# Stage 1 Road Safety Audit: Designers Response Report

Proposed Residential Development Access,  
Toddington Lane,  
Littlehampton,  
West Sussex, BN17 7PP

- 1.1 This report results from a Stage 1 Road Safety Audit carried out to assess a new access on to Toddington Lane and a new section of footway and crossing. This is in relation to the proposed development of 31 residential units. The stage 1 Road Safety Audit was undertaken by EC Road Safety.

Access Drawing / Visibility Splays

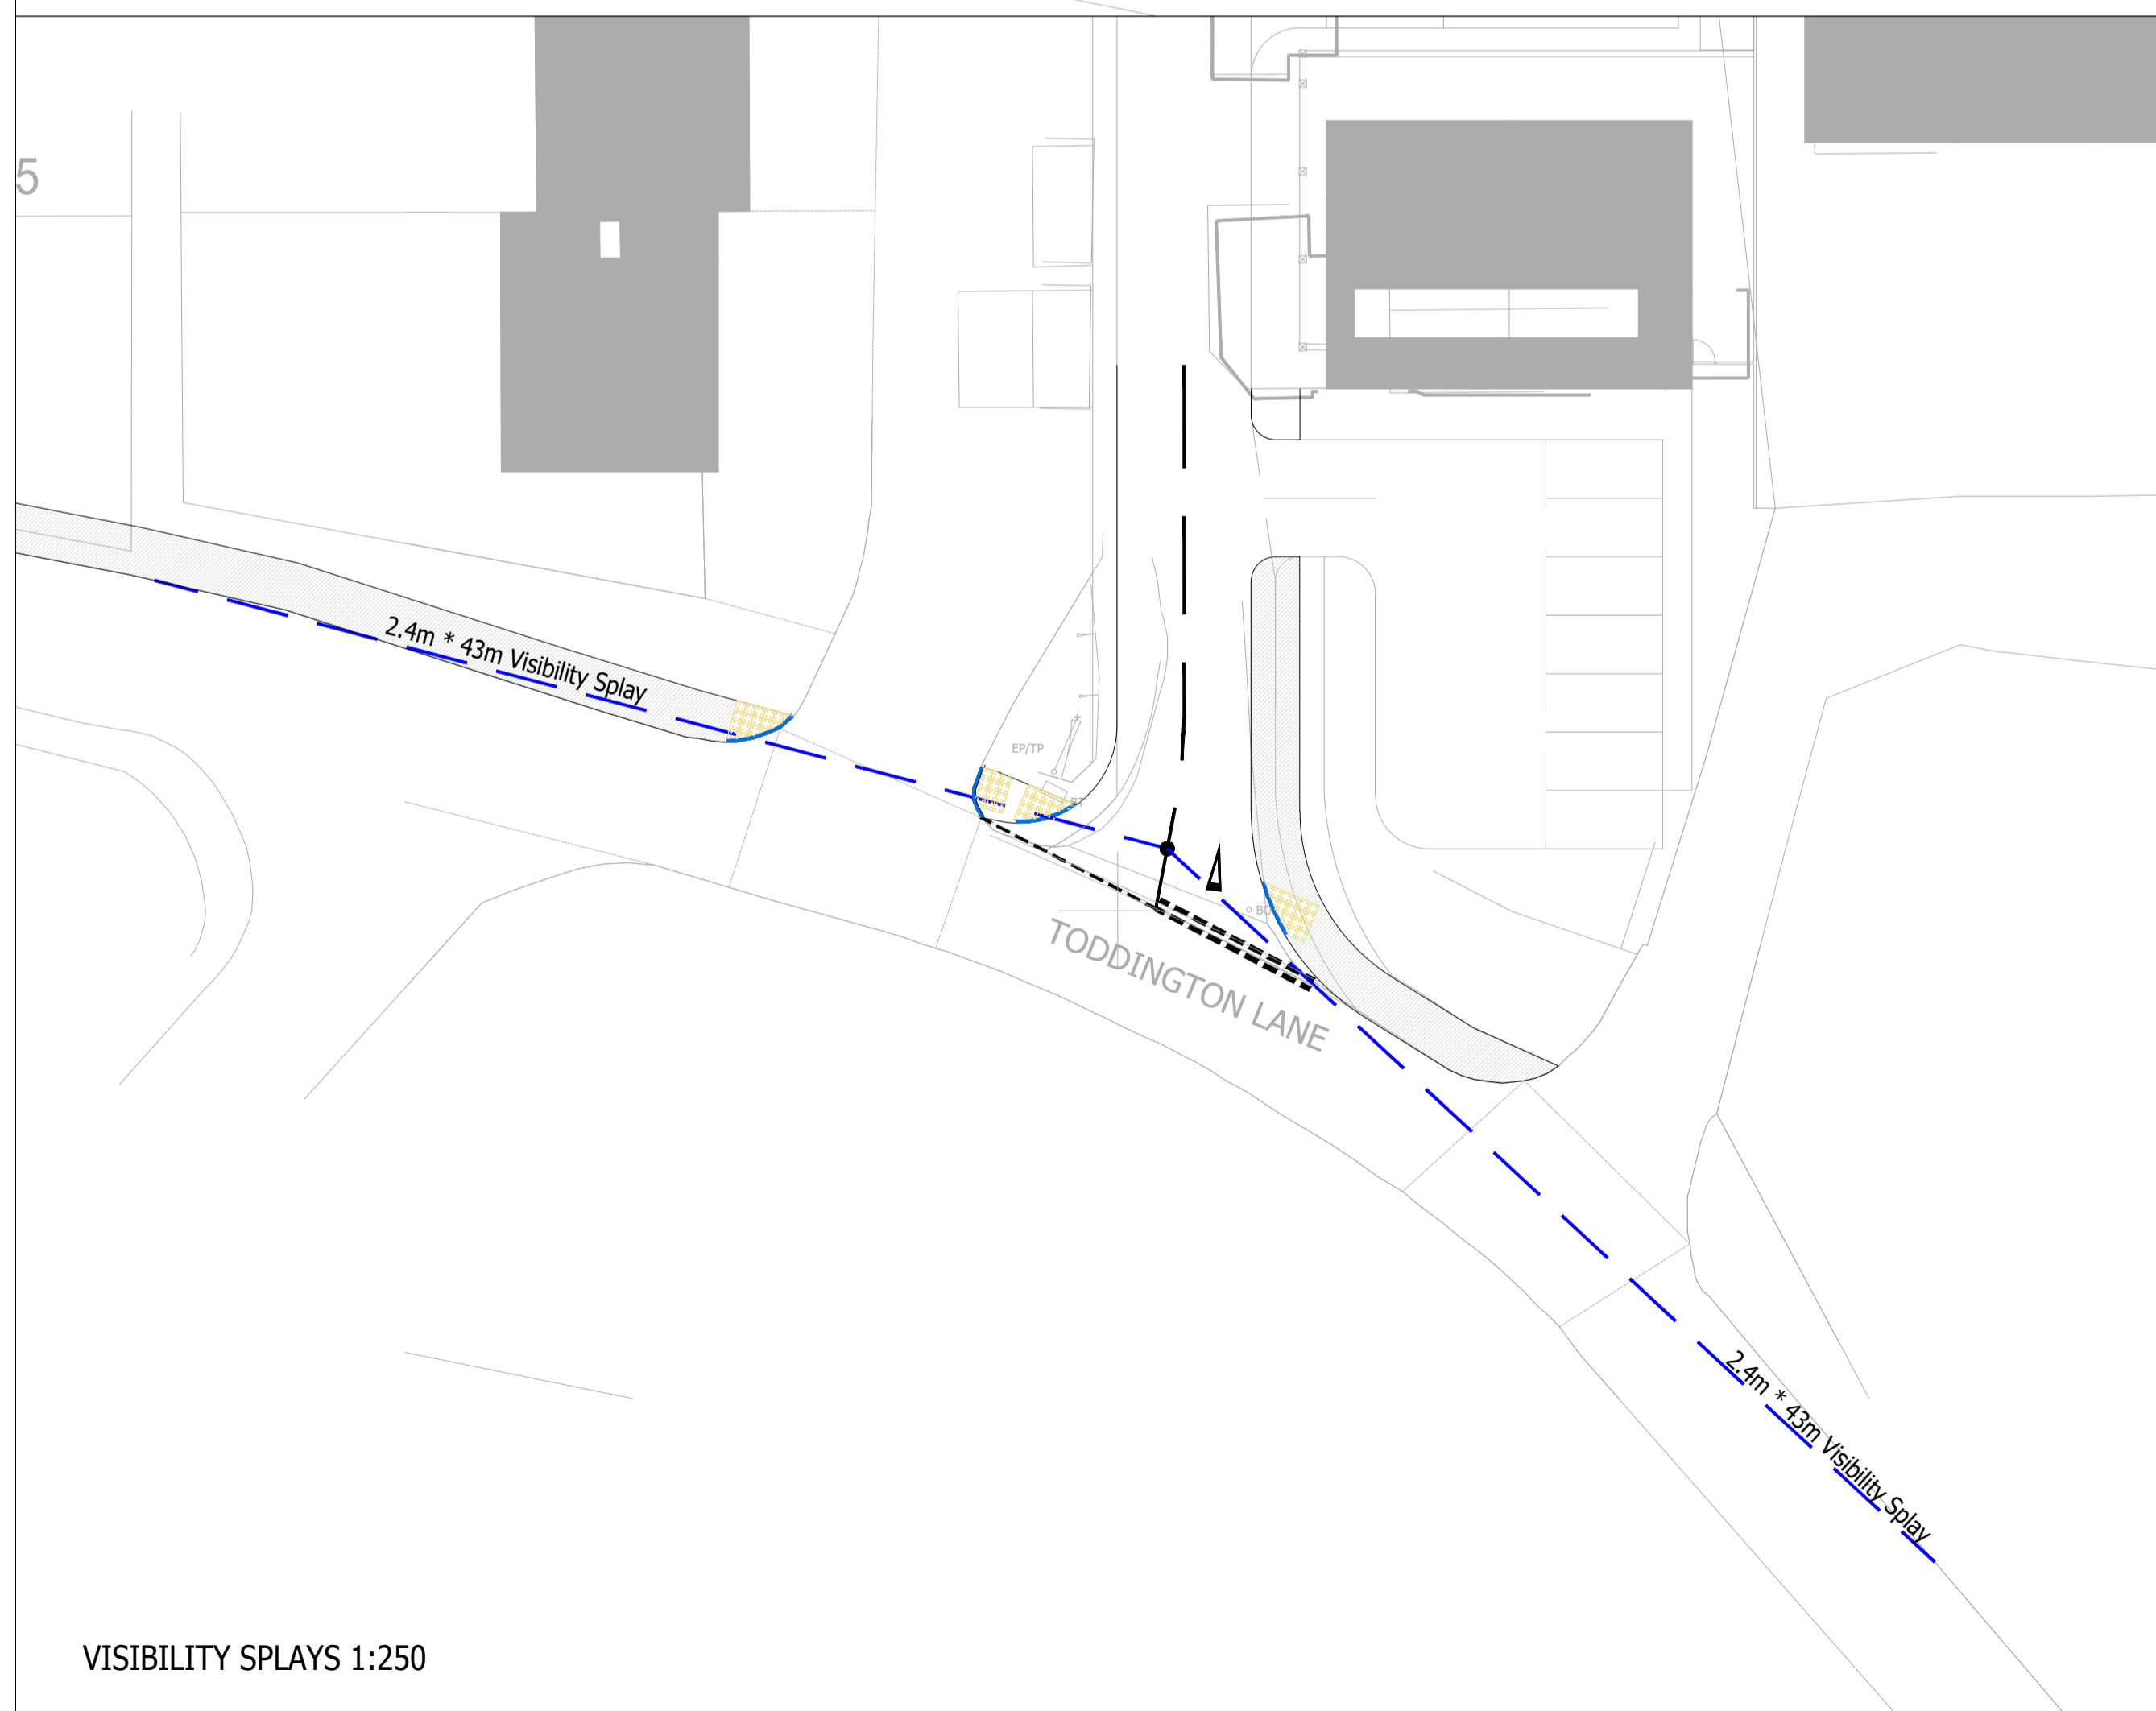
Problem	Location	Description	Recommendation	Design Organisation Response	Overseeing Organisation Response	Agreed RSA Action
3.1.1	Toddington Lane	Lack of footway continuity could result in pedestrian injury.	A strategic footway design / pedestrian route should be incorporated allowing for safe pedestrian access / egress at the site.	Agreed. The access plan includes a 60m long footway that connects to the existing footway on Toddington Lane, adjacent to Trevett Place. The proposed footway is located within the designated highway boundary and includes a crossing point with a dropped kerb and tactile paving.
